**NORTH
NORFOLK
DISTRICT
COUNCIL**

Norfolk Boreas Offshore Wind Farm

EXQ1: NNDC RESPONSE TO QUESTIONS ISSUED ON 19 NOVEMBER 2019

10 DEC 2019

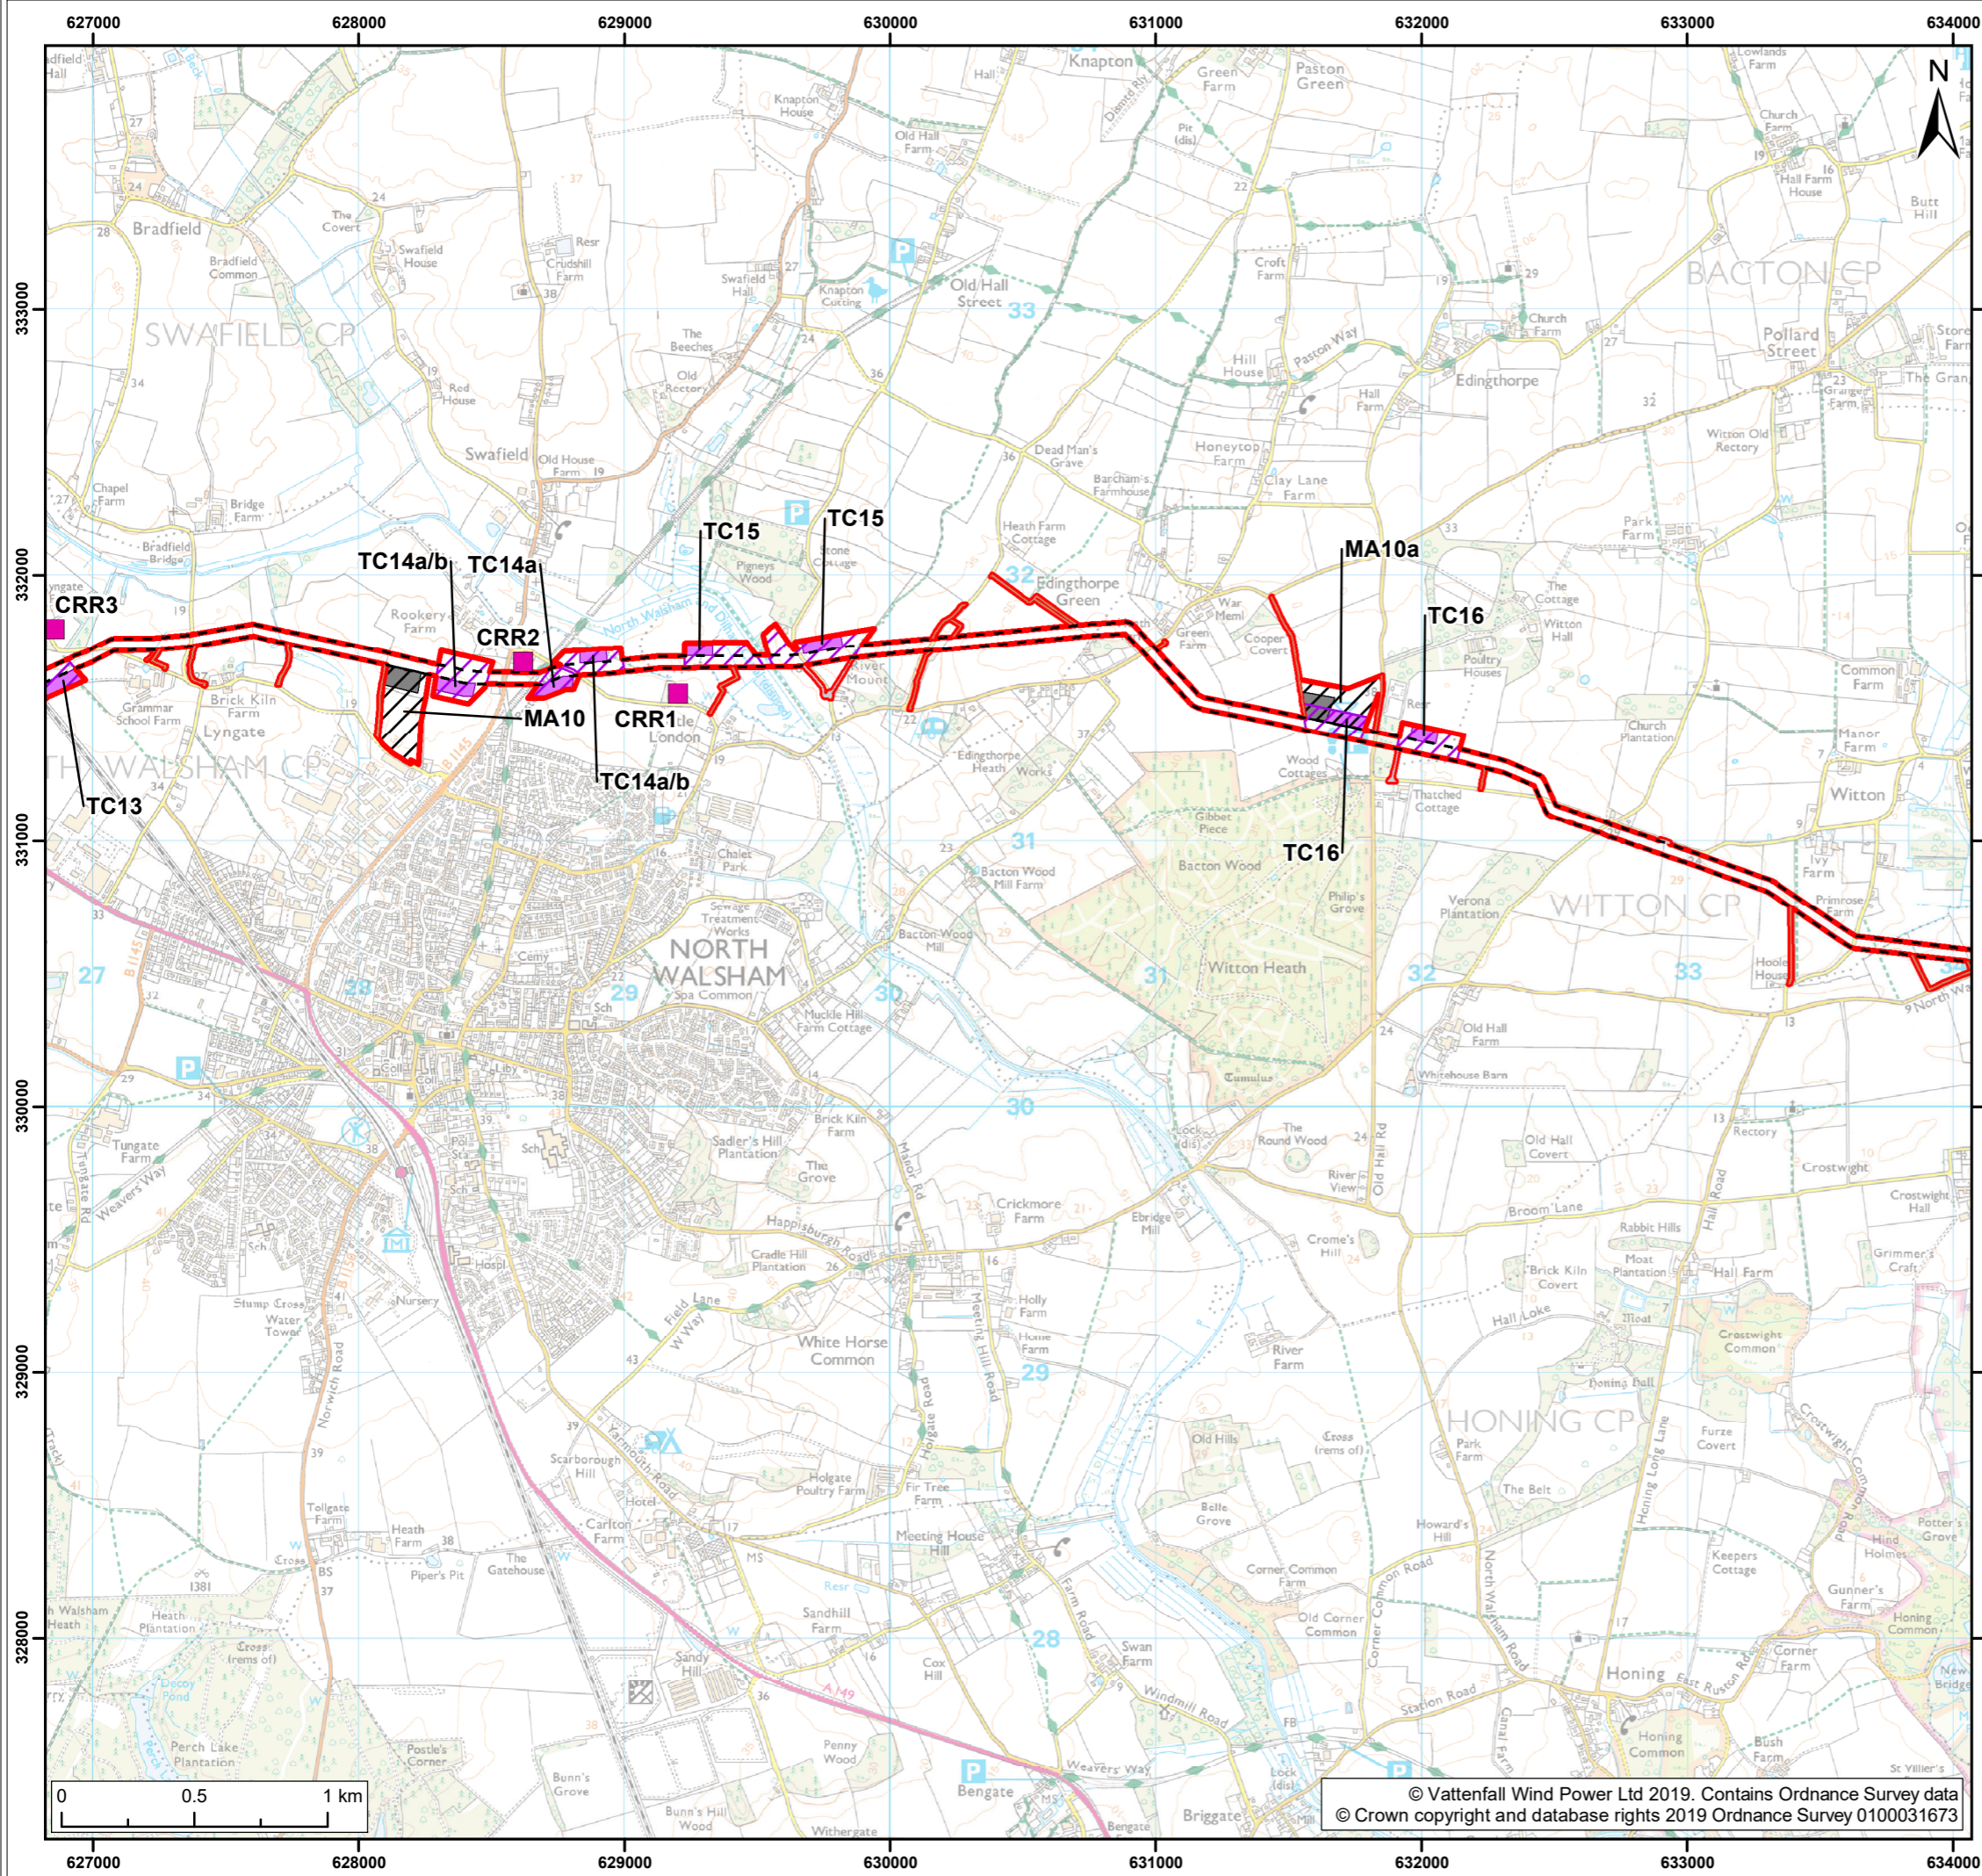
ExQ1 Question No.	Question to	Question	North Norfolk District Council Response
		<p>With reference to the location of noise sensitive receptors as identified in the ES Chapter 25 [APP-238, Figure 25.2], explain why:</p> <ol style="list-style-type: none"> 1. the majority of NSRs on Map 1 of 9 are located south of the cable route, although there are some potential receptors (e.g. Chimney Farm) to the north; 2. there are no NSRs in North Walsham close to the indicative mobilisation area (see Map 2 of 9); 3. there are no NSRs in proximity of trenchless crossing (TC) 16, although there are residential properties in proximity of this area (see map 2 of 9); 4. there are no NSRs in proximity of TC6, although there are a number of farms in proximity of this area (see Map 6 of 9)? 5. IPs may wish to comment. 	
Socio-economic effects			
Q13.2.1	Norfolk County Council North Norfolk District Council	<p>Effects on tourism and recreation In light of the significance of tourism to the local economy, particularly tourism along the coast, are you content that the ES Chapter 30 Tourism and Recreation [APP-243]</p>	<p>NNDC have provided extensive submissions within Section 14 of its Local Impact Report related to Tourism, Recreation and Socio-Economics. The Statement of Common Ground (2.11 Tourism, Recreation and Socio-economics)</p>
